**RE: Transmittal of Comments – Ridgway Short Plat (SP-07-00039)**

SUBJECT: Ridgway Short Plat SP-07-39

**RIDGWAY SHORT PLAT
PART OF SECTION 21, T. 18 N., R. 19 E., W.M.
KITITAS COUNTY, WASHINGTON**

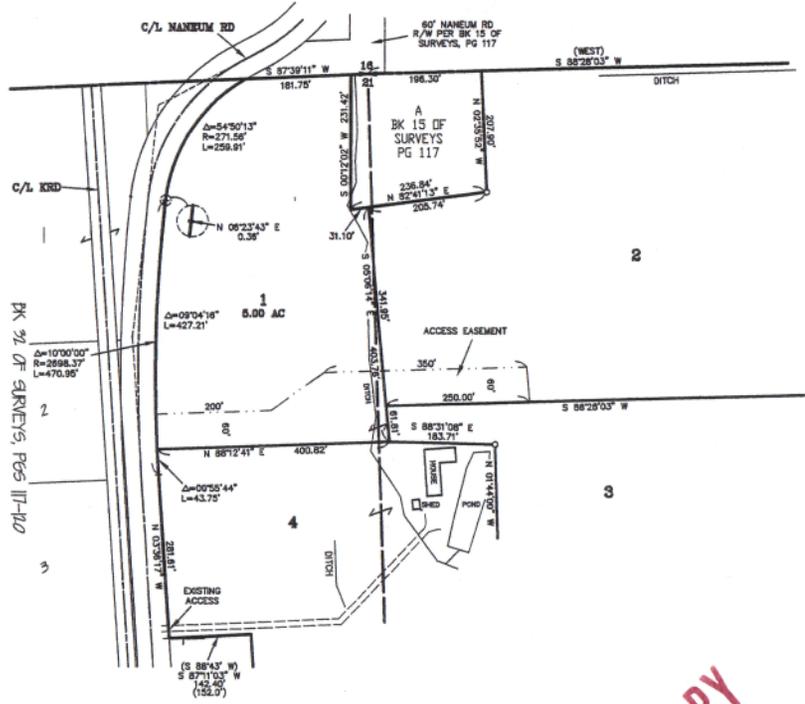
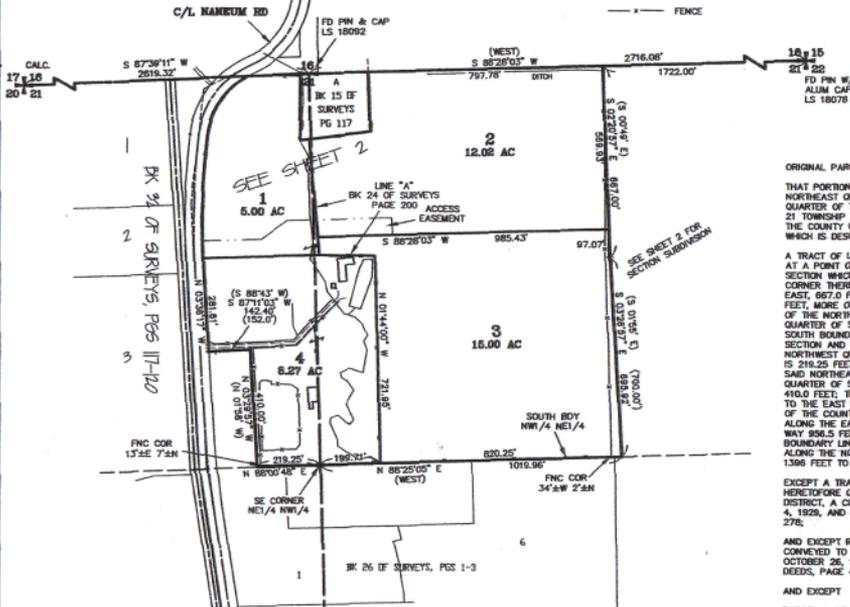
3. Turnaround: Either a hammerhead or a cul-de-sac turnaround may be constructed in the designated area on Lot 1. Cul-de-sacs and hammerheads must conform to the requirements specified by the 2006 International Fire Code. Contact the Fire Marshal regarding any additional turnaround requirements.

4. Private Road Improvements: Access shall be constructed to meet or exceed the requirements of a High-Density Private Road that serves 3-14 tax parcels. See Kittitas County Road Standards, 9/6/05 edition.

- a. Access easements shall be a minimum of 40' wide. The roadway shall have a minimum width of 20', with 1' shoulders, for a total width of 22'.
  - b. Minimum centerline radius will be 60'.

- c. Surface requirement is for a minimum gravel surface depth of 6".
  - d. Maximum grade 8% flat, 12% rolling or mountainous.
  - e. Stopping site distance, reference AASHTO.

- j. All easements shall provide for AASHTO radius at the intersection with a county road.
  - k. A paved apron shall be constructed at the intersection of the proposed private intersection and the county road.
